<b>Client</b>	Hawthorn
<b>Project</b>	Portland, ME
<b>Lead Designer</b>	
<b>Production Manager</b>	Jason DiOrazio
<b>Production Staff</b>

SHEET
 A4.5

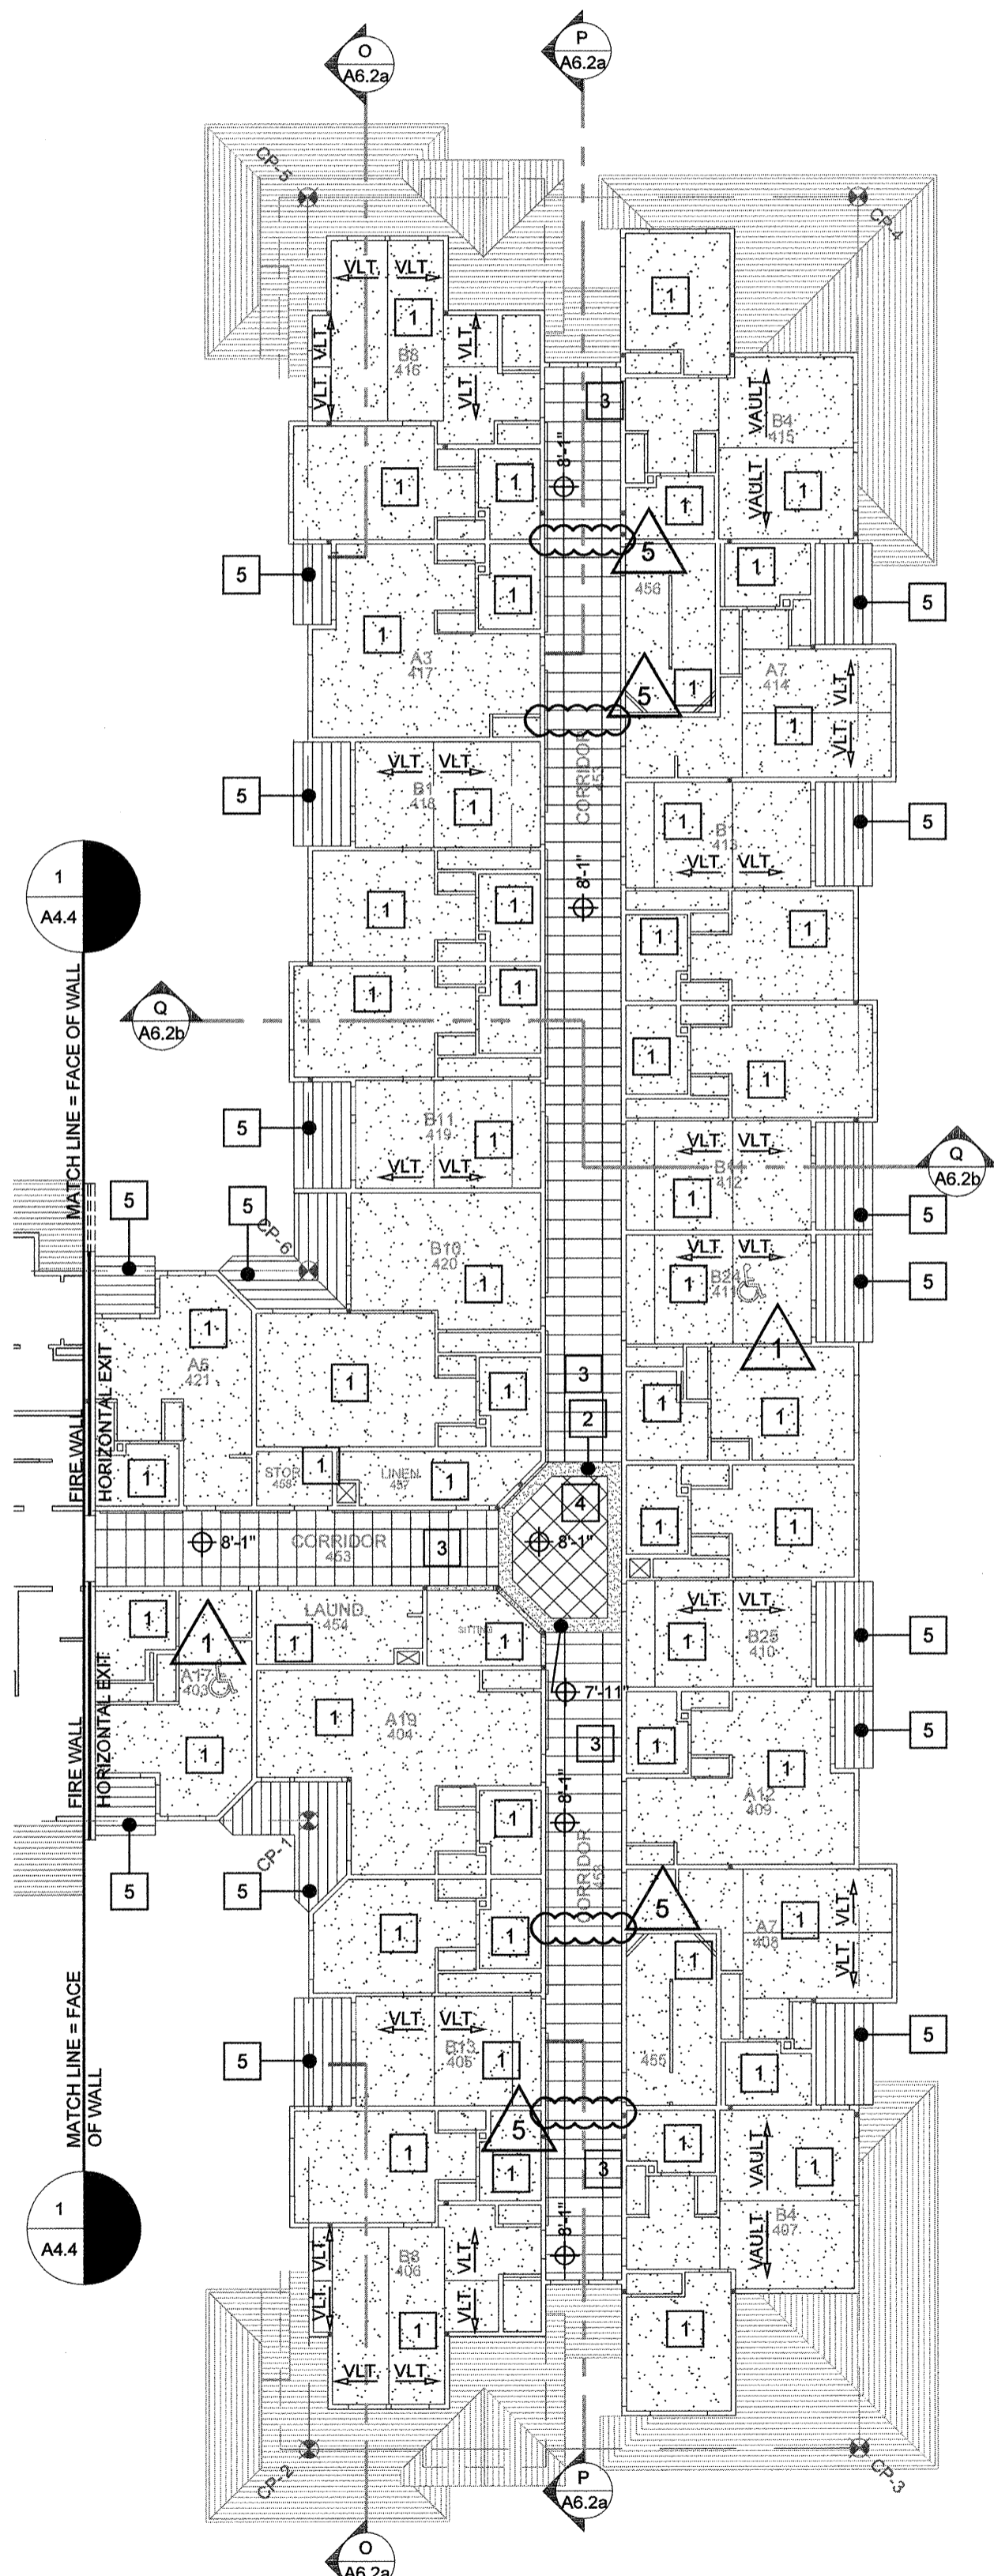
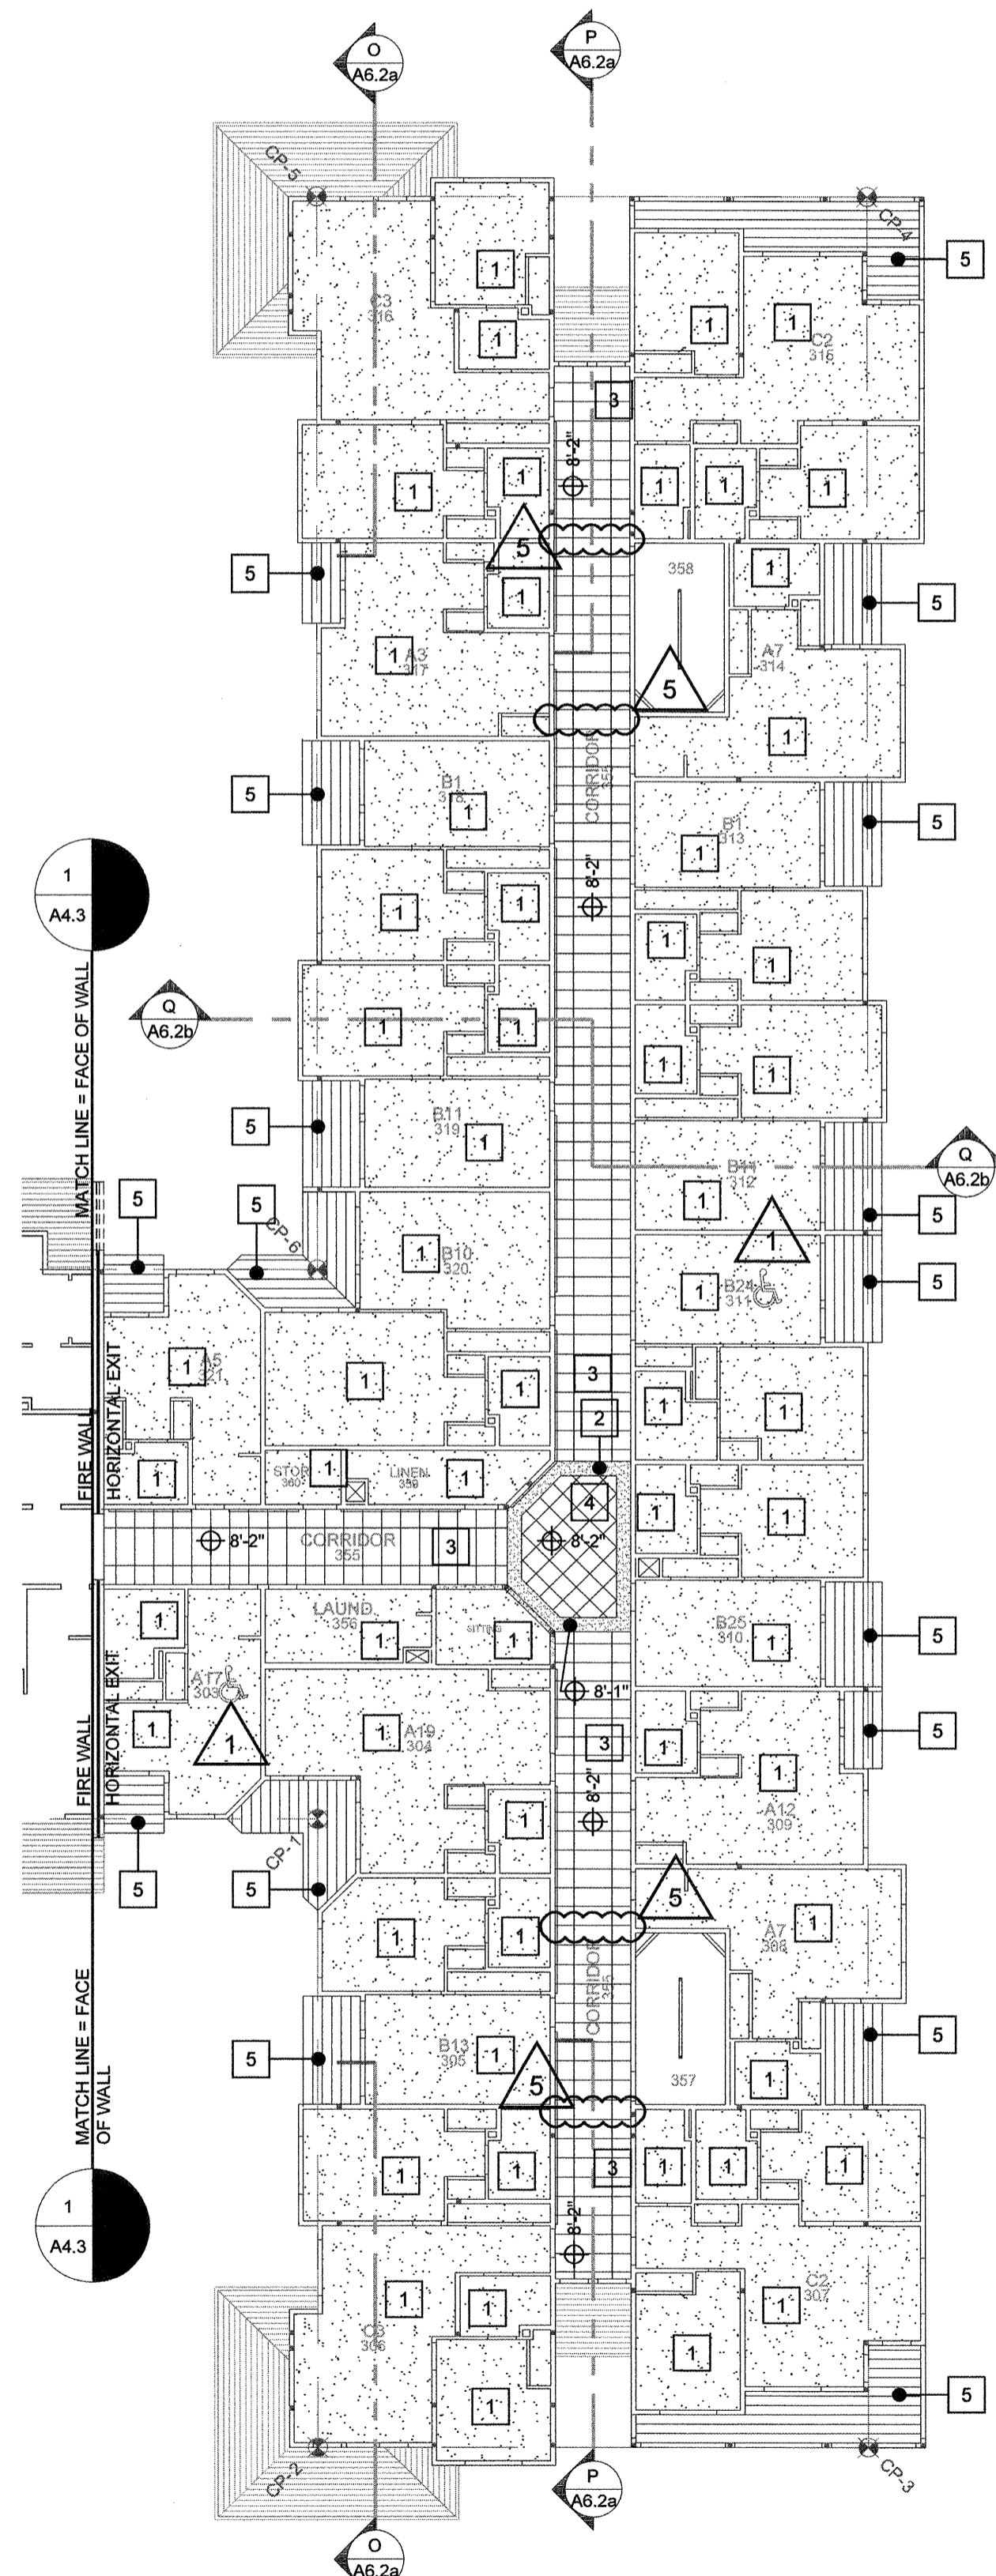
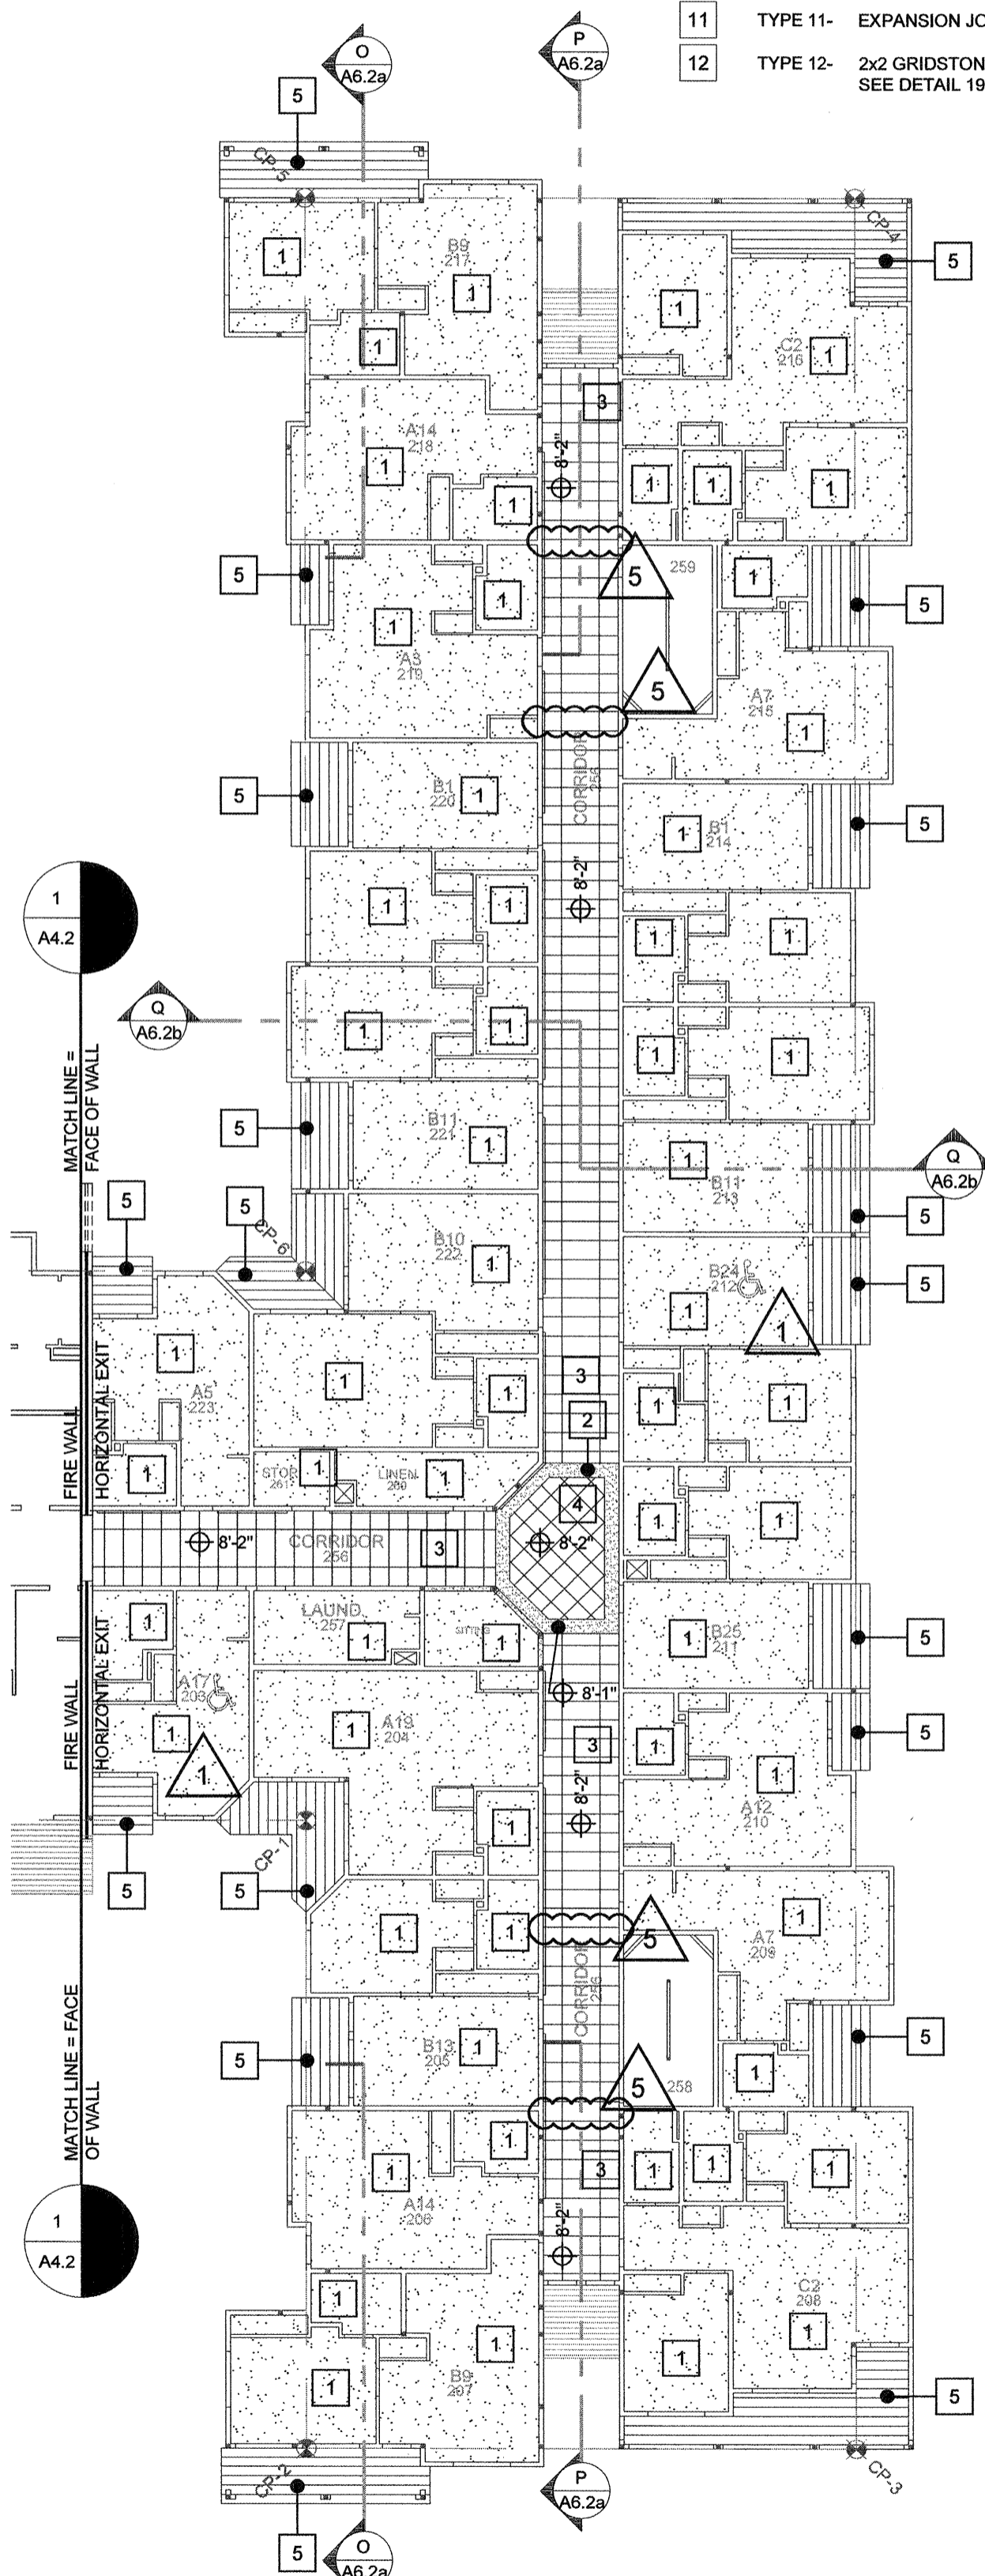
5	A4.3	Soffit removed in corridor, added soffits in B7 unit 339	Y			8/26/2016
5	A4.4	Soffit removed in corridor	Y			8/26/2016
5	A4.5	Soffits removed in corridor - all floors	Y			8/26/2016
5	A4.6	Soffits revised at corridor "turn" at floors 1-3, soffits removed in corridor all floors	Y			8/26/2016
5	A4.7	Soffits in Private Dining revised	Y			8/26/2016
5	A5.1	Added key boxes at Office, louvered door added to Co-Manager unit, time rating/clarification added at all mechanical case callouts, louvered door added to Laundry room	Y			8/26/2016
